WELWYN HATFIELD COUNCIL – DEVELOPMENT CONTROL
DELEGATED REPORT

APPLICATION No:	S6/2008/1158/FP
------------------------	-----------------

The proposed development would involve the erection of a detached garage with accommodation within the roofspace. This addition would measure 14.5m in width by 6.2m in depth with a ridged roof to a maximum height of 7.5m. The northern and southern planes of the roof would have pitched roofed dormer windows measuring 1.5m in width by 3.0m in height. The flank elevations of this building would have an ornate design with circular windows. The agent has stated that the proposed side elevations are based on the lost curvilinear Dutch gables, which existed on the house before 1790. The garage has been illustrated to have a weather vane which would have a height of 8.6m from the adjacent ground level.

Garage 6103/2/10

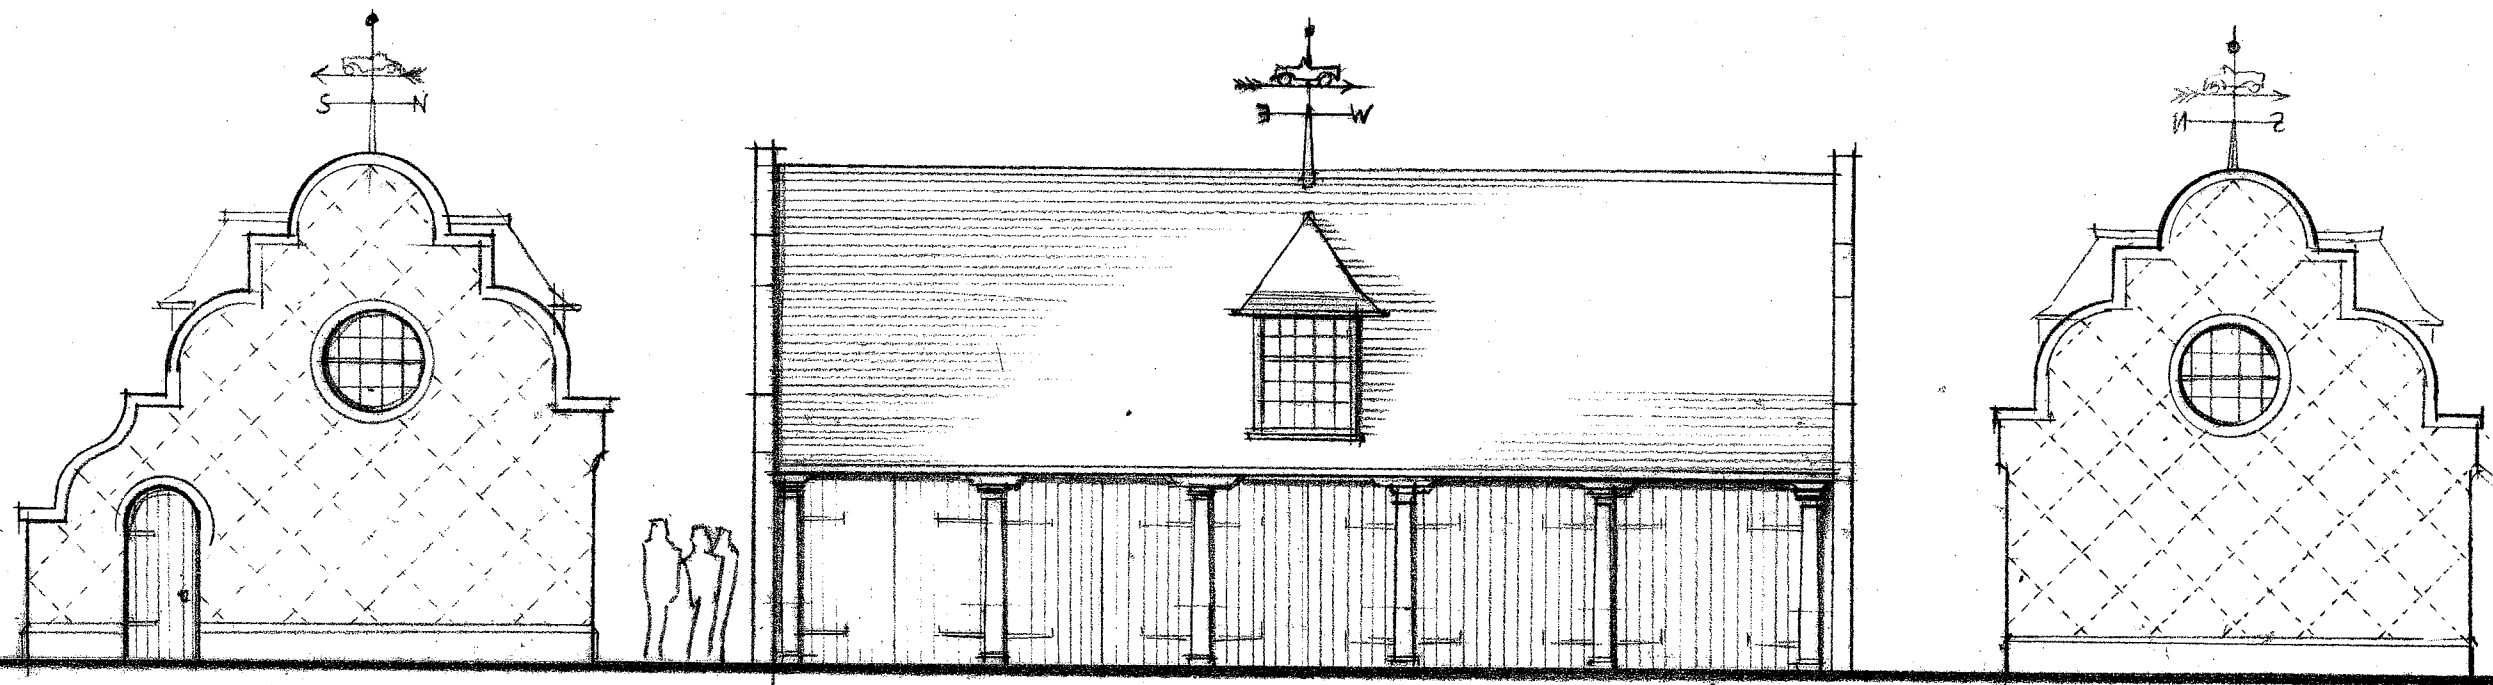
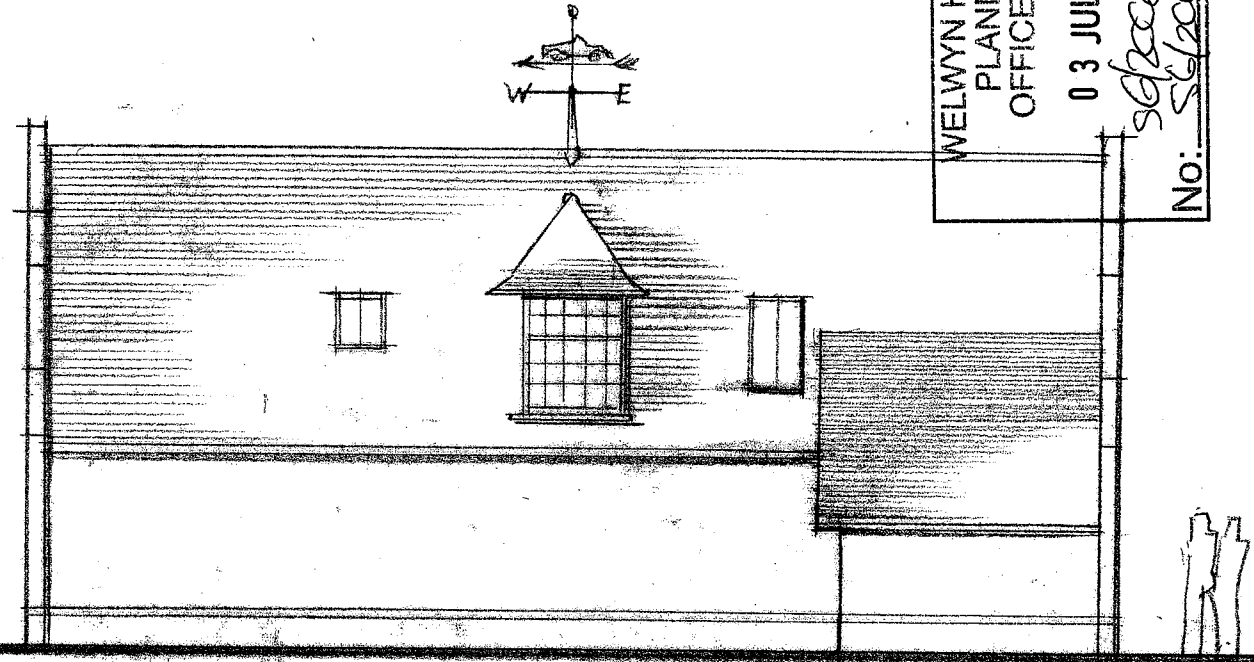
The proposed development would create a separate unit with residential accommodation above. Due to the design of the proposal it would have glazing at roof level, which would be noticeable from the surrounding area. The proposal would be viewed from Wilkins Green Lane and would be seen when approaching the main building. The proposed garage building would be within the same streetscene and clearly be on the same plot as the main building. The proposal would have a maximum height of approximately 6.8m, which would mean that the building is viewed clearly above the adjacent boundary. Due to the proposed ornate design of the flank elevations and overall prominence of the building, it would have an adverse impact upon the setting of the main Listed Building. It has been acknowledged that the design has been based on a previous feature of the main building. However, this addition would not reflect the existing Listed Building and would not enhance its setting.

When considered cumulatively with the recently approved entrance gates and pillars the, the appearance of the proposal would be exacerbated. The proposed garage building would have an inappropriate design that would detract from the appearance of the Listed Building. The proposed building would also be excessive in terms of its mass, bulk and prominence. When considering with the proposed garages and proximity to the adjacent highway, it would have an adverse impact upon the character, appearance and setting of the Listed Building. The proposed development would therefore be contrary to PPG15.

The proposed garage building would be a large and bulky addition set away from the existing property. This addition would be prominent and spread development away from the main dwelling, which would have an adverse impact upon the open character of the Green Belt. The proposed garage building would appear two storey and overly prominent within the existing street scene. The proposed garage building would also incorporate a separate residential unit within the roofspace. This addition would be very independent from the main dwelling and is considered to be an inappropriate addition within the Green Belt.

The proposed detached garage would form a highly prominent structure within the immediate setting of the main house. The garage would detract from the appearance of the Listed Building and have a detrimental impact upon the existing character and appearance of the locality. There is insufficient evidence to justify such a significant change and harmful impact to their overall appearance. The proposal therefore does not comply with the requirements of Policy D2 of the Welwyn Hatfield District Plan 2005 and PPG15 (Planning and the Historic Environment).
